**CITY OF ALBUQUERQUE
Planning Department
August 17, 2005
DRB Comments**

PROJECT #1004369

Re: Country Club Townhomes/sketch plat

**DEVELOPMENT REVIEW BOARD
TRANSPORTATION DEVELOPMENT
Standard Comment Sheet**

PROPOSED RE-PLAT

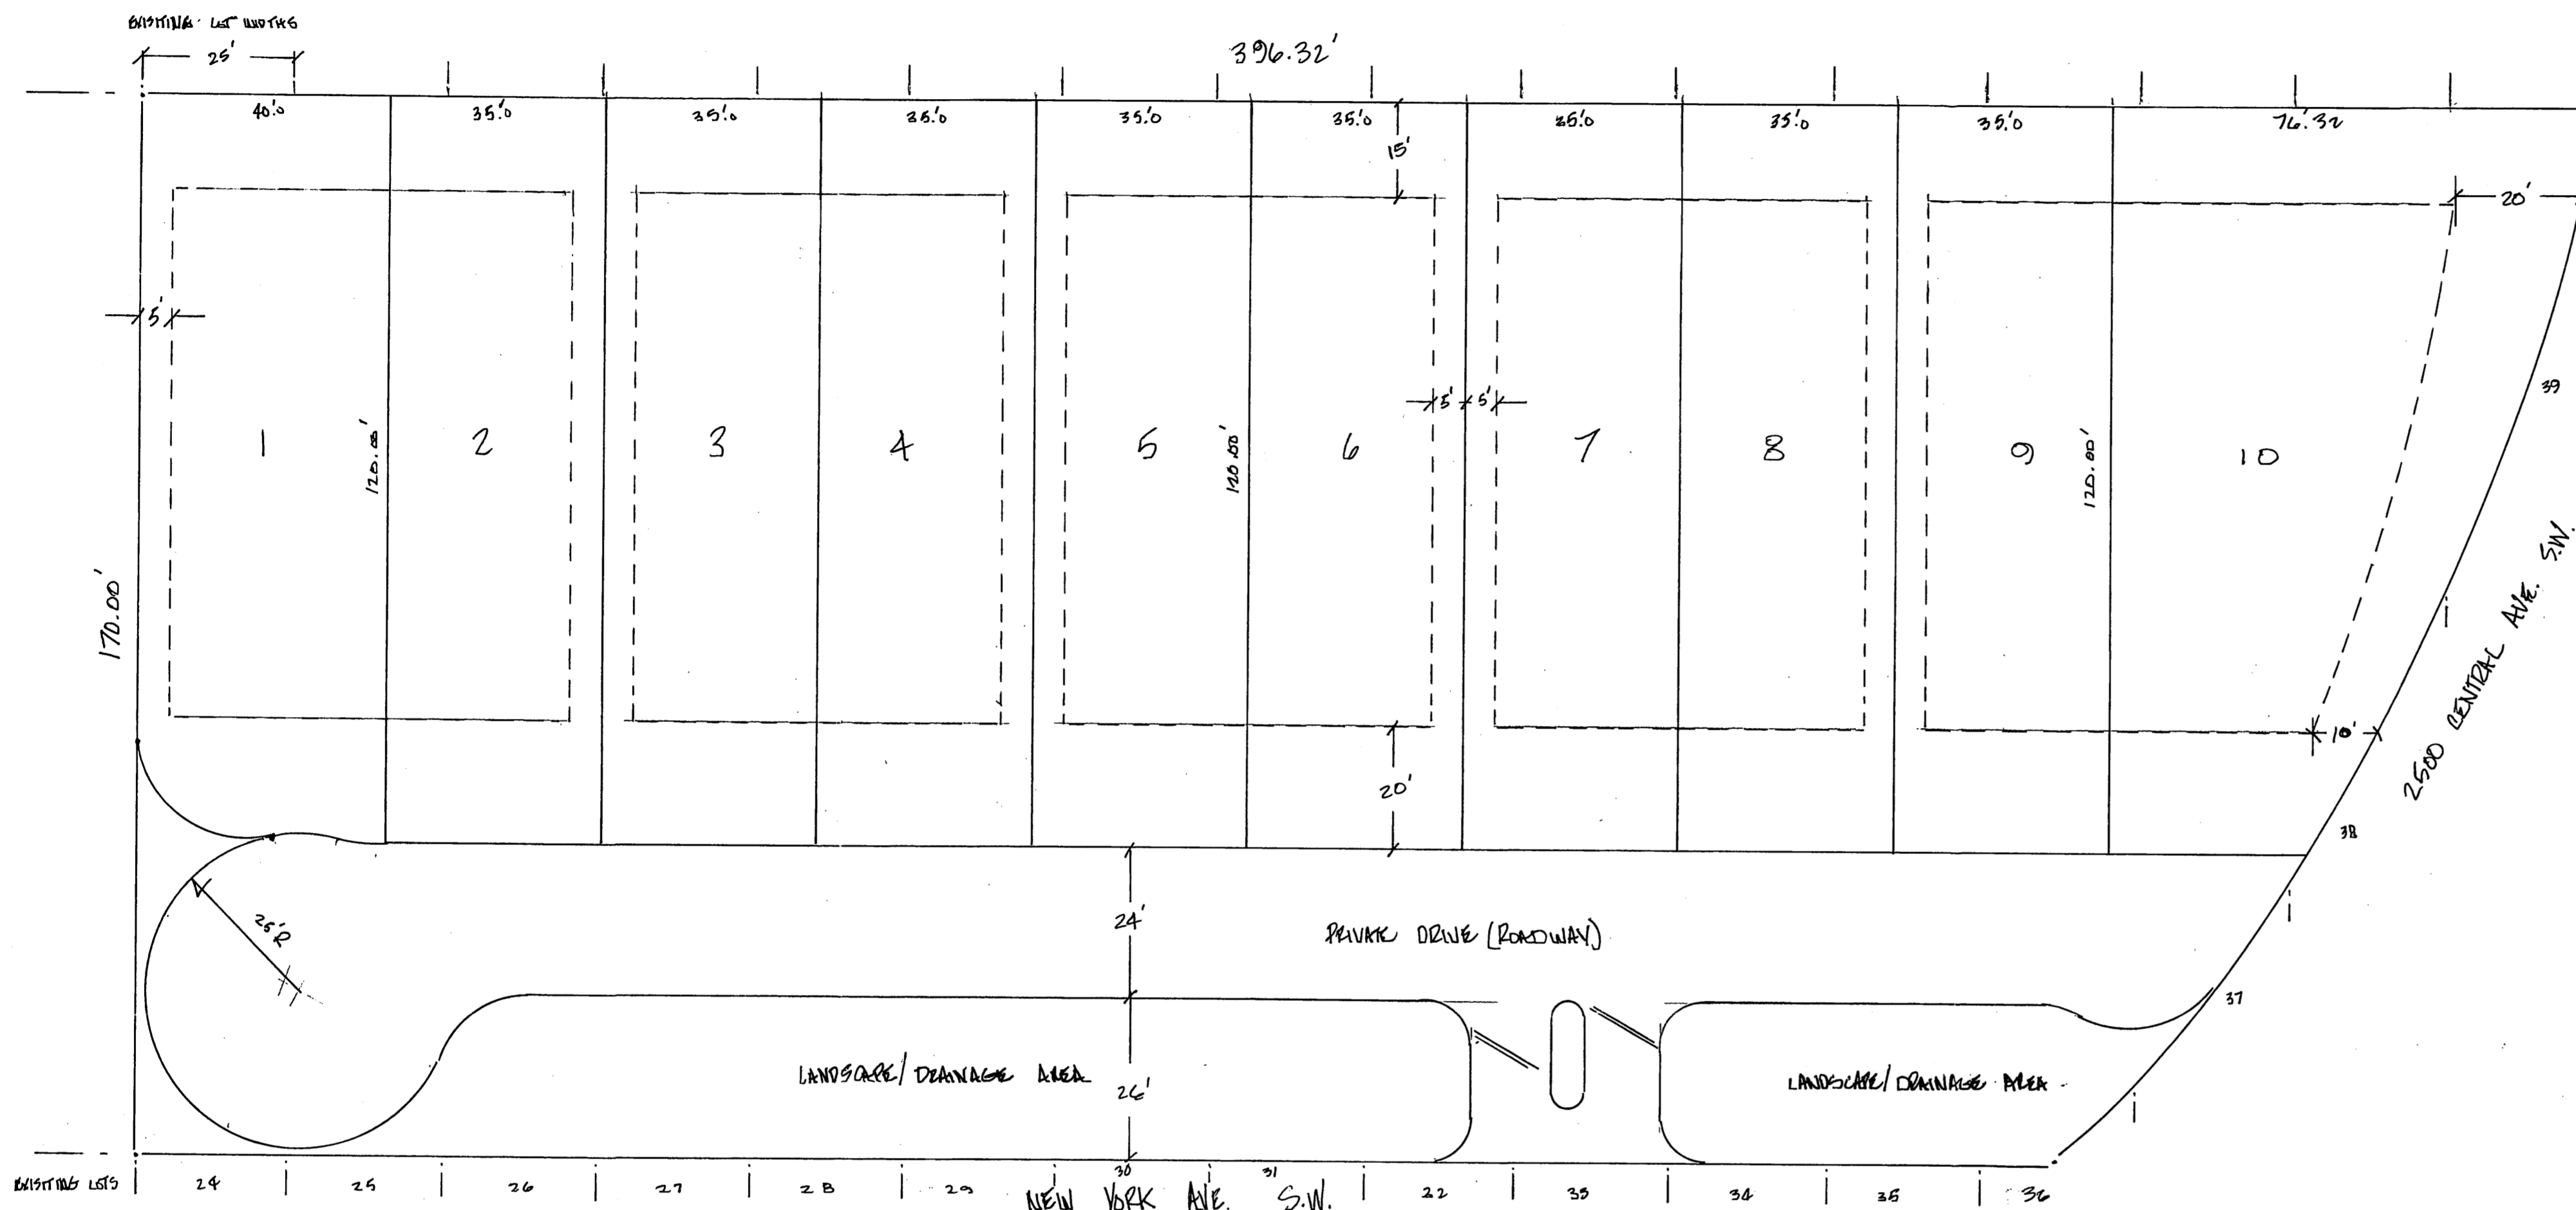
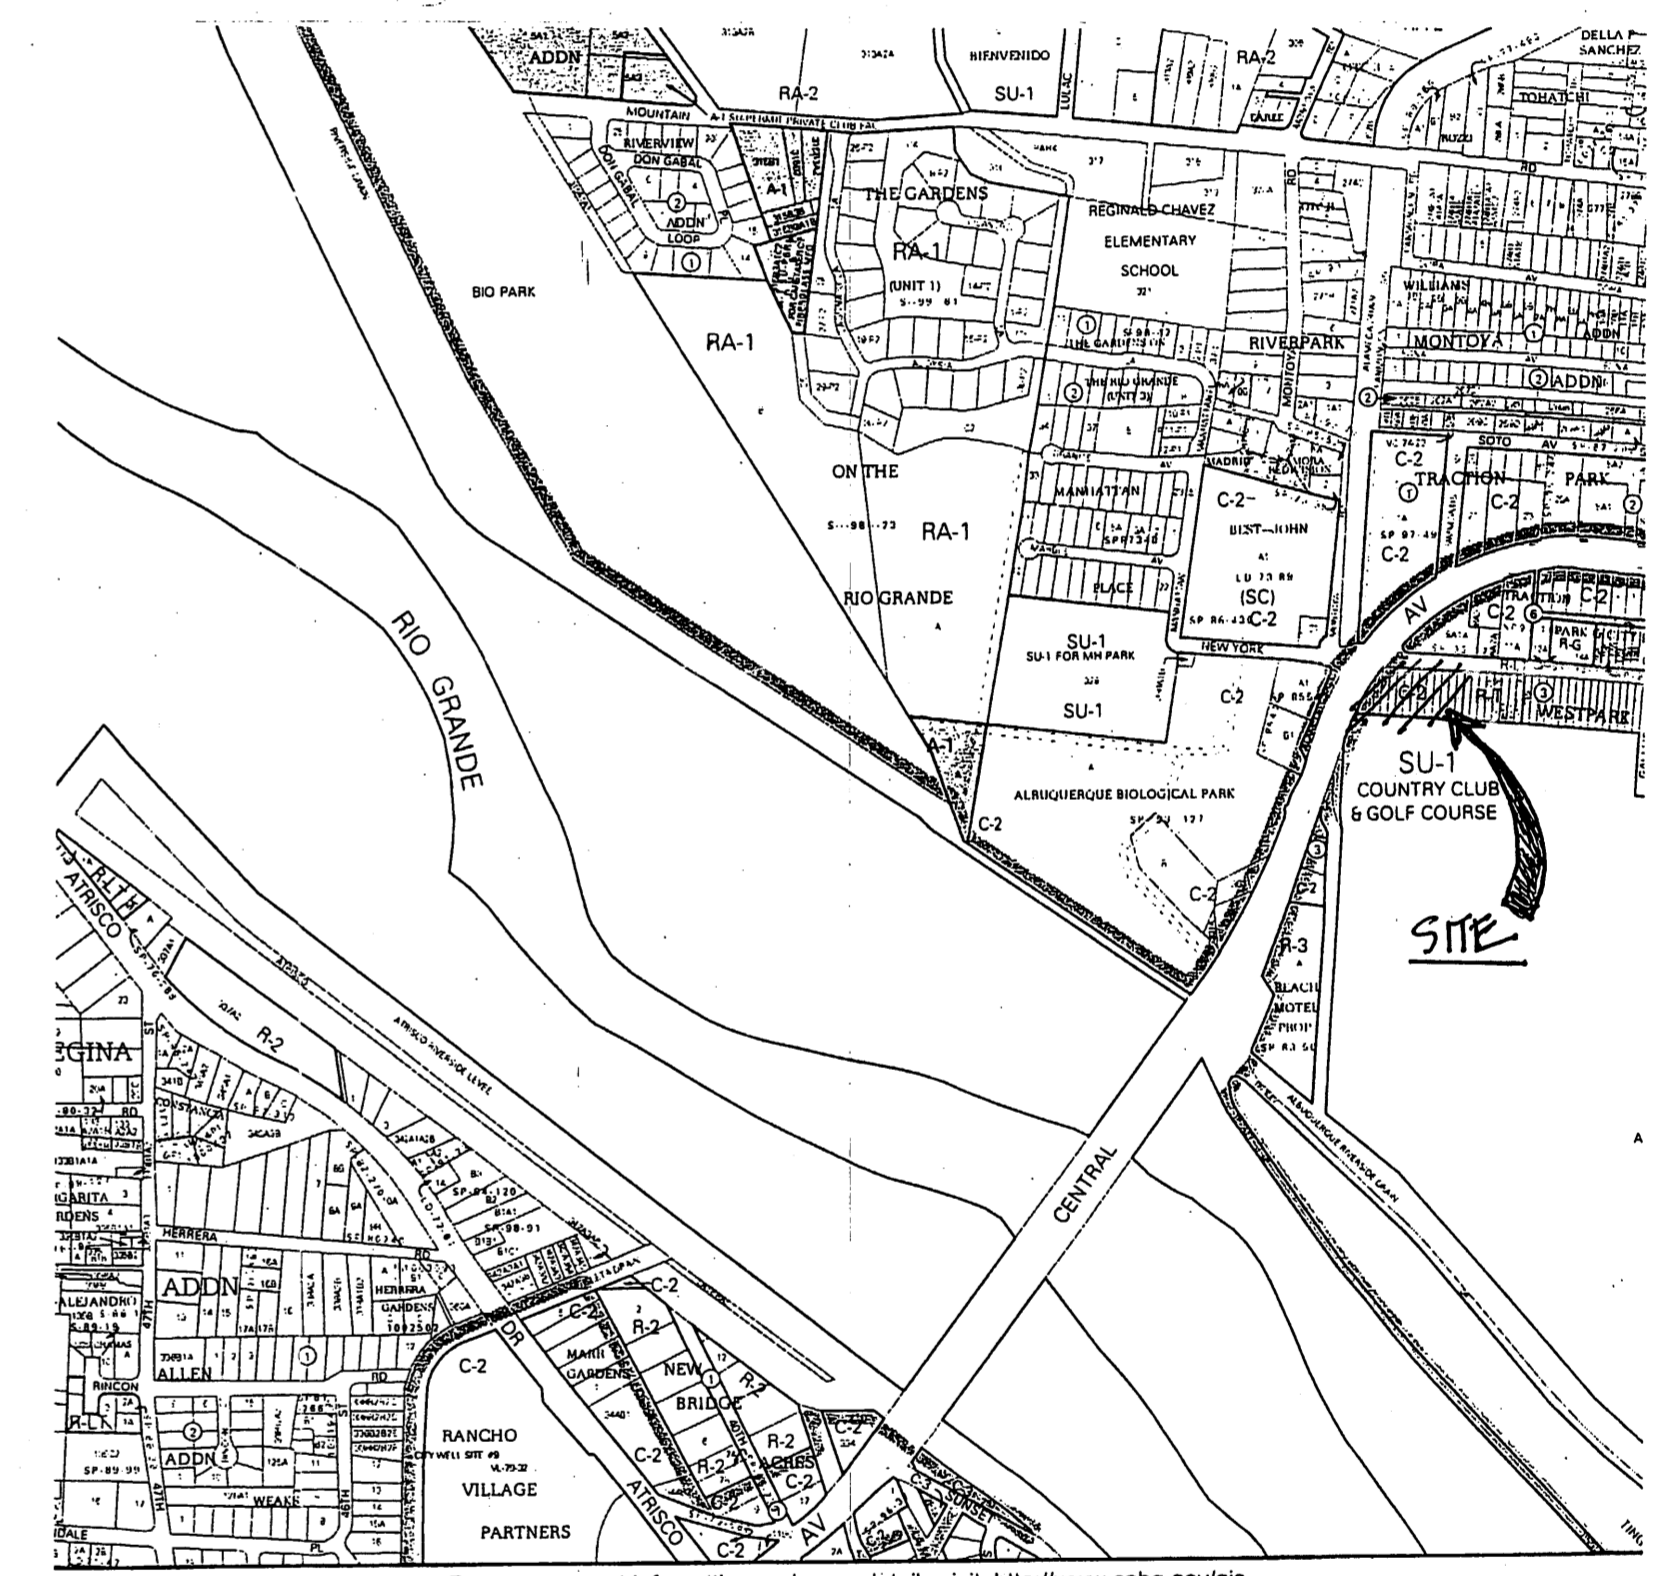
A conditional use to allow townhouse development is required prior to Planning approval.

- 1) Standard infrastructure per DPM is required.
- 2) Are these P1 lots? Width of road needs to be 26' F-F with a 44' r/w for this designation.
- 3) The cul-de-sac requires a 40' radius with P1 designations.
- 4) Applicant will need to provide a cross-section of New York to evaluate whether dedication and/or improvements are needed.
- 5) A queing analysis will be needed for the gated entrance.
- 6) Can vehicles turn around before the gate?
- 7) Is the sidewalk in place along Central? What is the r/w width?

An approved grading and drainage report must be on file prior to Preliminary Plat approval.
This project will need an infrastructure list.
